PROPOSED RESIDENTIAL SUBDIVISION AT MUNDAMIA FOR TWYNAM MUNDAMIA PTY LTD

Our Ref: DOC12/142822
Your Ref: dwg 25489 – 01
26 November 2012

| PROPOSED DEVELOPMENT: | Subdivision at Mundamia – Lot 3 DP 568613 and Lot 384 DP755952 |

Notification of proposed development adjoining Crown land

REF. No.	25489-01	REVISION:
SHEET	1	OF 1 SHEETS
	04

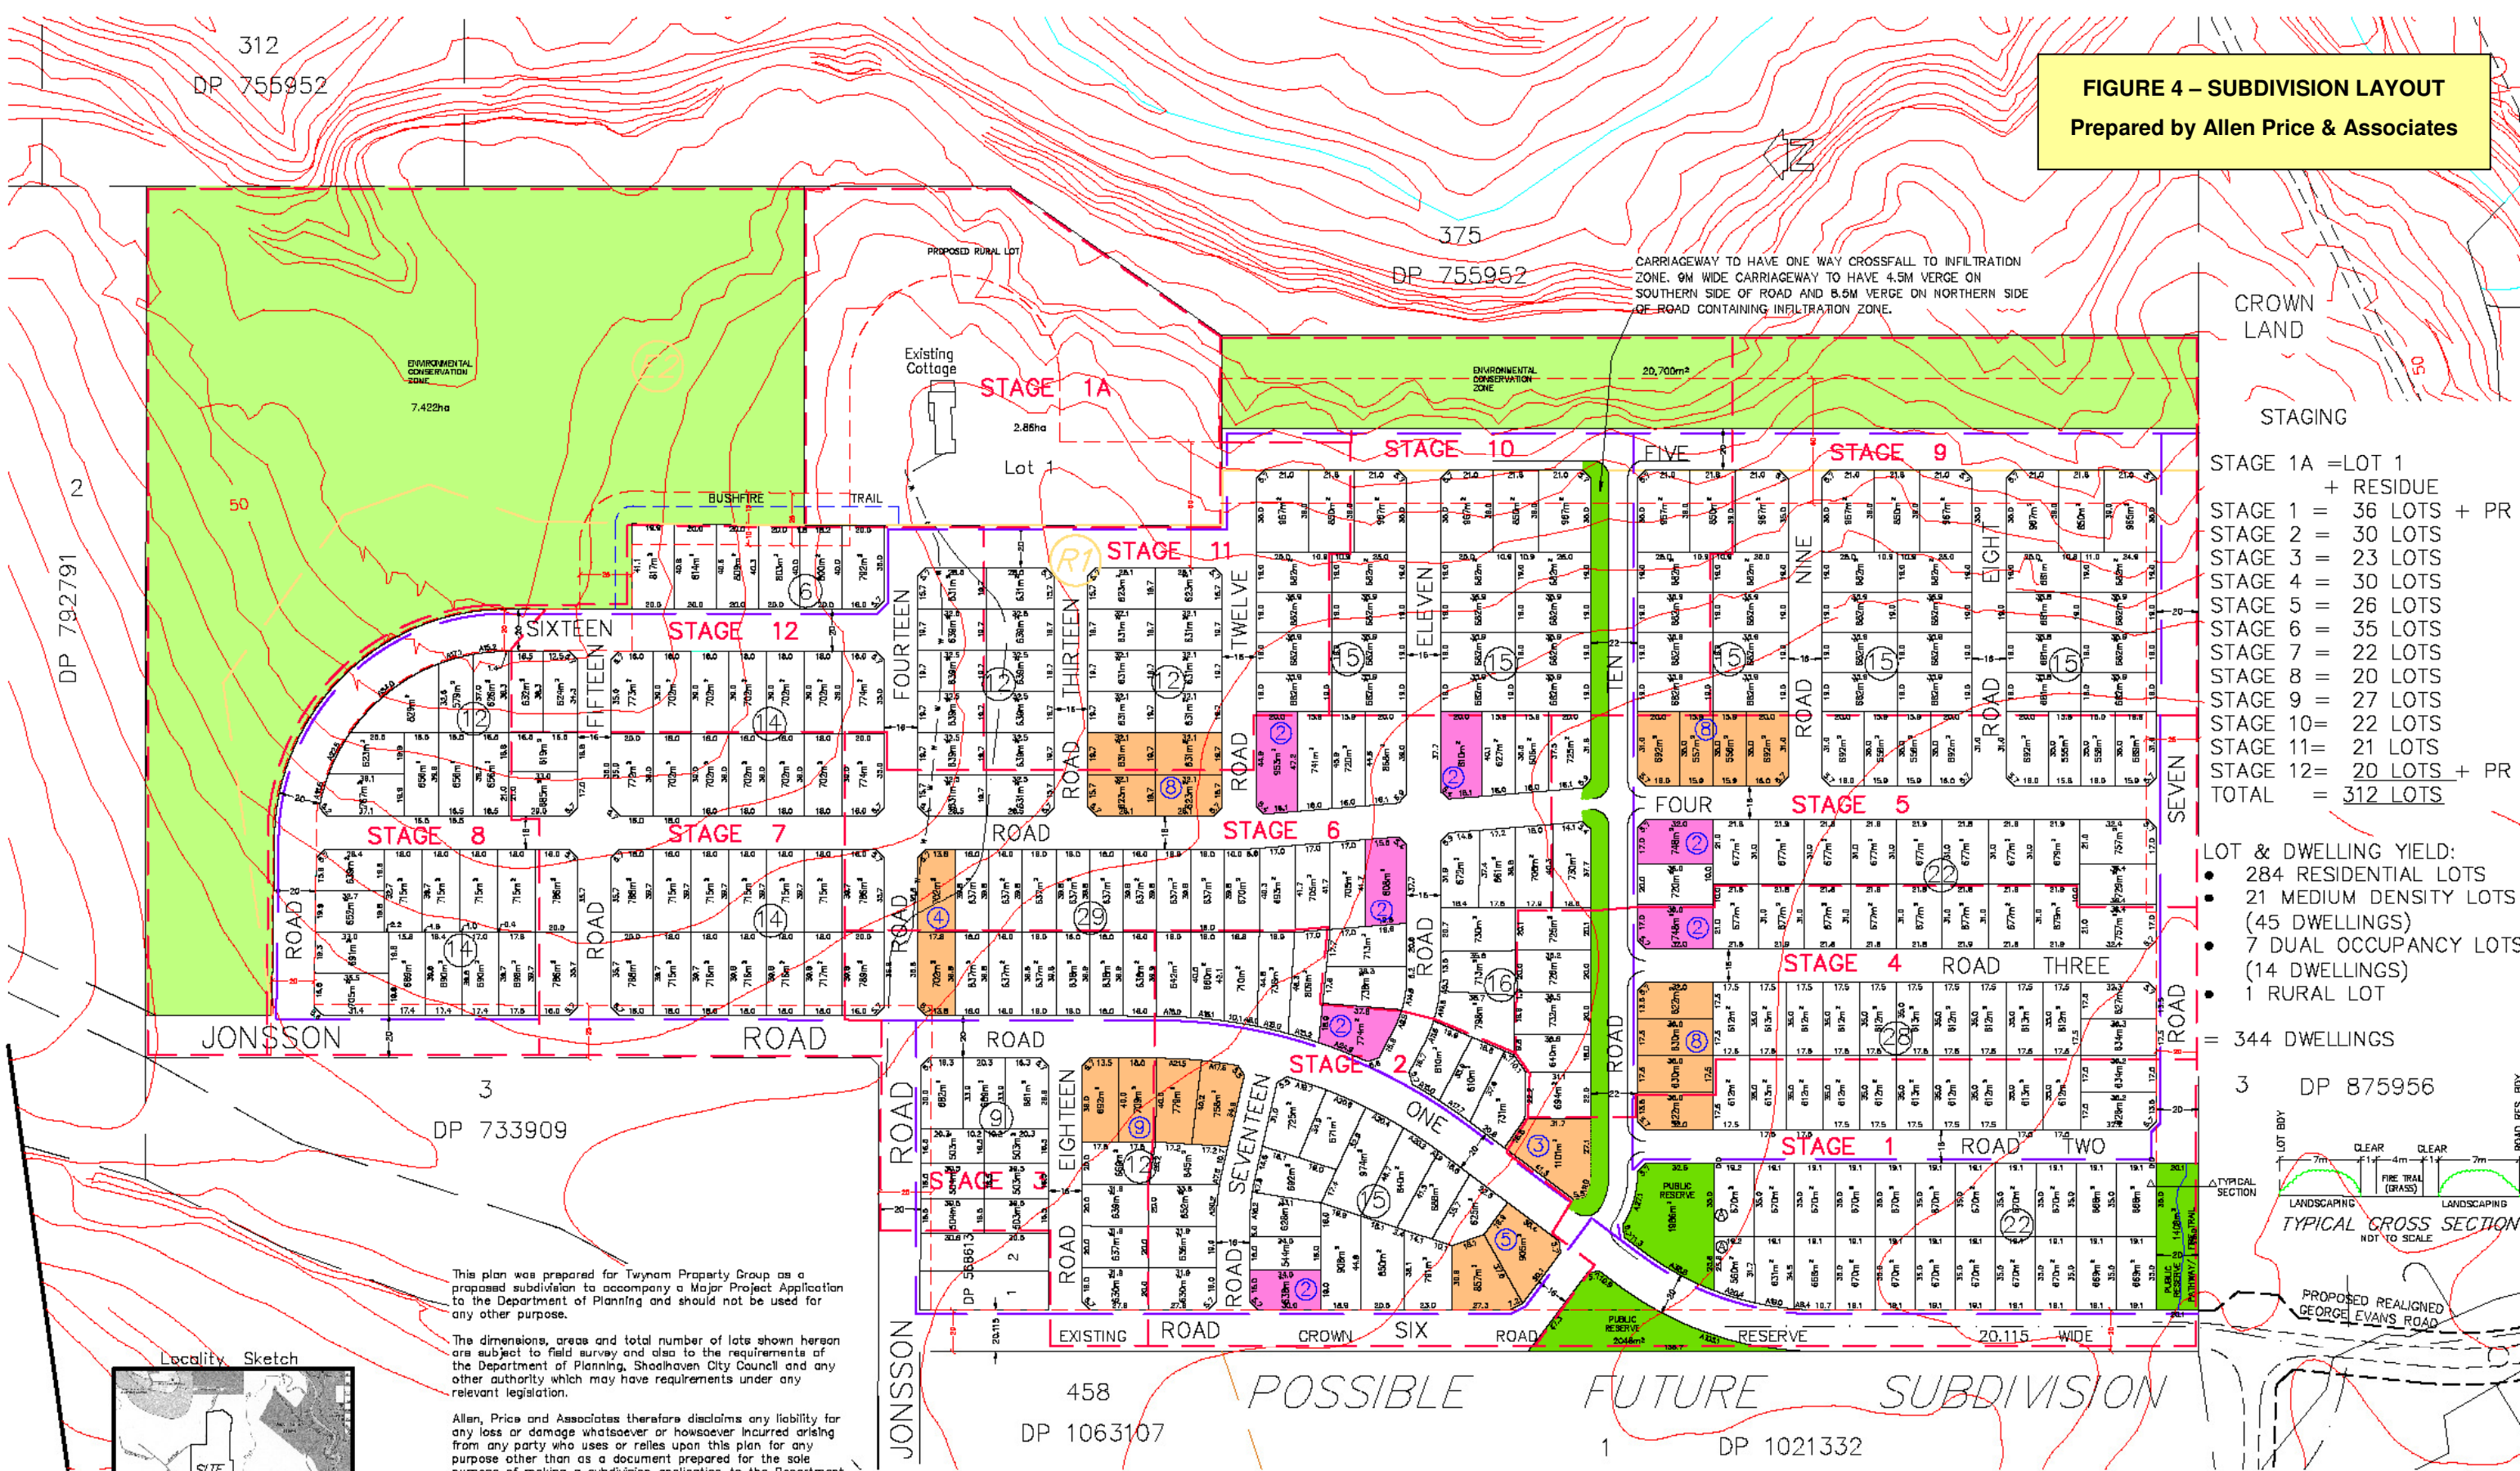
The proposal involves Crown roads that are proposed to be constructed and/or included in the development. No approval has been given by the department under the provisions of the Roads Act 1993 for the construction of the adjoining Crown roads.

In accordance with departmental policy any Crown roads proposed to be upgraded or utilised for access in conjunction with a development or subdivision proposal must be transferred to Council for management as a Council public road. Should Council decline to accept control of the road, any access or construction works being proposed on these roads will not be authorised.

The proposed development also adjoins Lot 7324 DP 1166433, being Crown reserve R755952 for Future Public requirements. The proposal must not:

- Encroach upon or remove any vegetation from the adjacent Crown land,
- Stockpile materials, equipment or machinery on the adjacent or adjoining Crown land,
- Use the adjacent and adjoining Crown land as access, including Crown roads prior to transfer to Council.
- Use the un-constructed Crown roads for any purpose other than that of access nor undertake any works on the land to facilitate vehicle access, prior to transfer to Council.
- Direct stormwater discharges, septic or contaminated waste on the adjacent and adjoining Crown land, or
- Use the adjacent and adjoining Crown land as effluent management zones or as asset protection zones.

Furthermore, no reserves created within the subdivision are to vest in the Crown.
